Your Ref :
Our Ref : AL/44/14/NMA

Section 96A of the Town & Country Planning Act 1990 (as amended)
Town and Country Planning (Development Management Procedure) (England) Order 2010 (as amended) - Article 9

Application for Non-Material amendment following a grant of planning permission AL/89/10 - relating to minor external changes to fenestration within approved elevations to plot 4 only. Land rear of Swan Court, Pine Close, Westergate, Aldingbourne

Plot 4
A3 @ 1:100

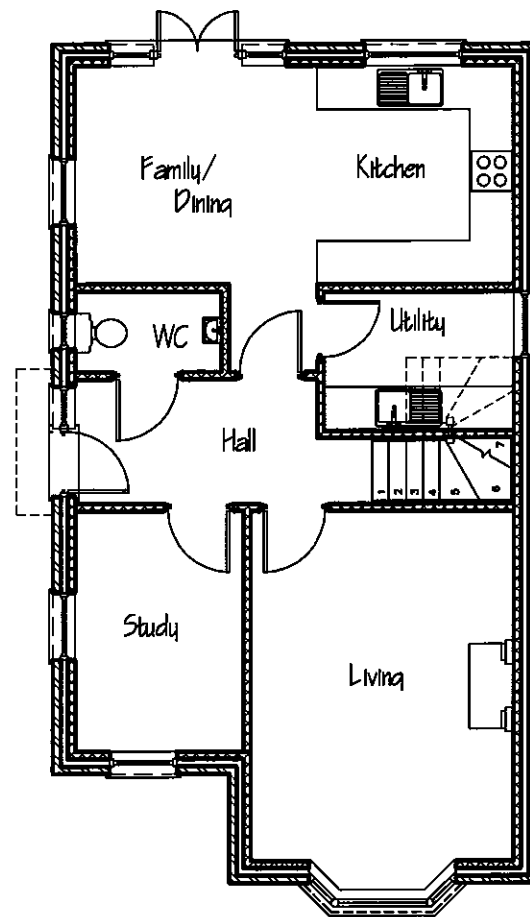
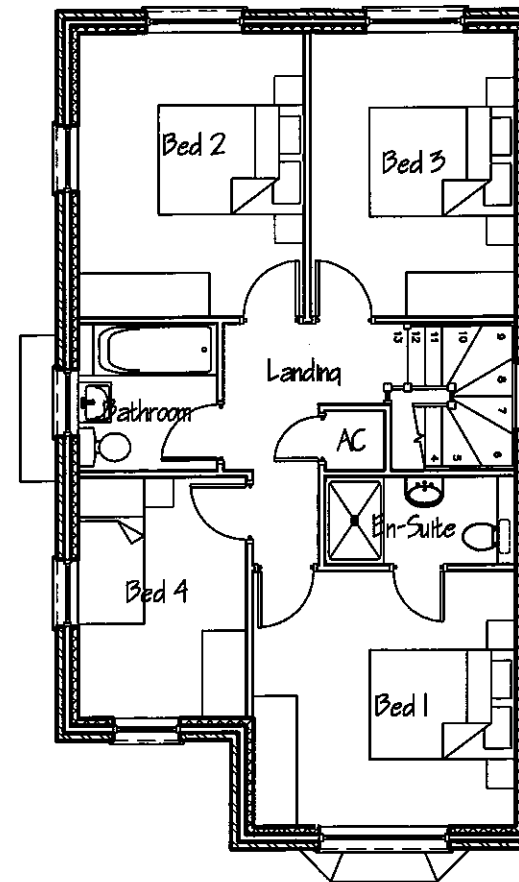
Obscure glazed windows on the side elevation serving the landing and en-suite and the removal of the utility room window at ground floor level.

The above changes can be accepted as a non material amendment to planning approval AL/89/10. The submitted Floor Drg No 1643/08b and Elevations Drg No 1643/09 now become the approved plans for Plot 4.

Elevations - Plots 1-4

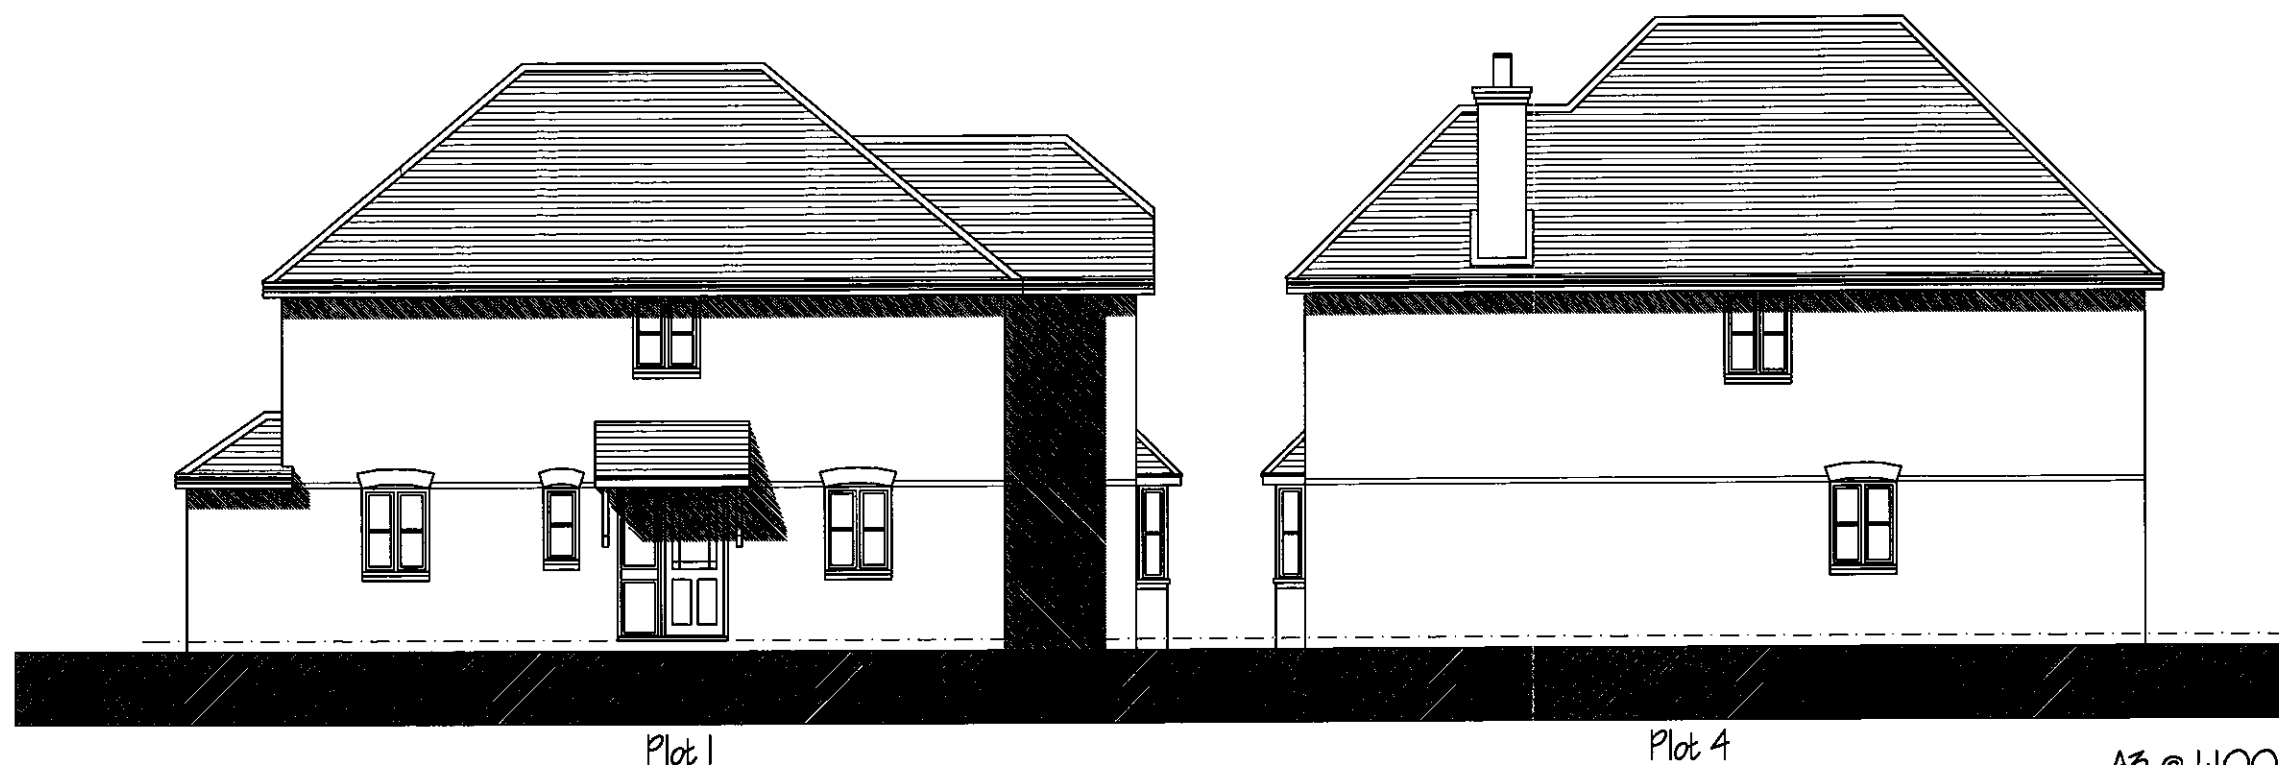
Introduction of two false windows and obscure glazed window on the side elevation.

Change in roof tile from Dreadnought tiles - sand faced brown heather to plain clay roof tiles.

Red multi facing brickwork.

Terracotta brick string course, sills and arches.
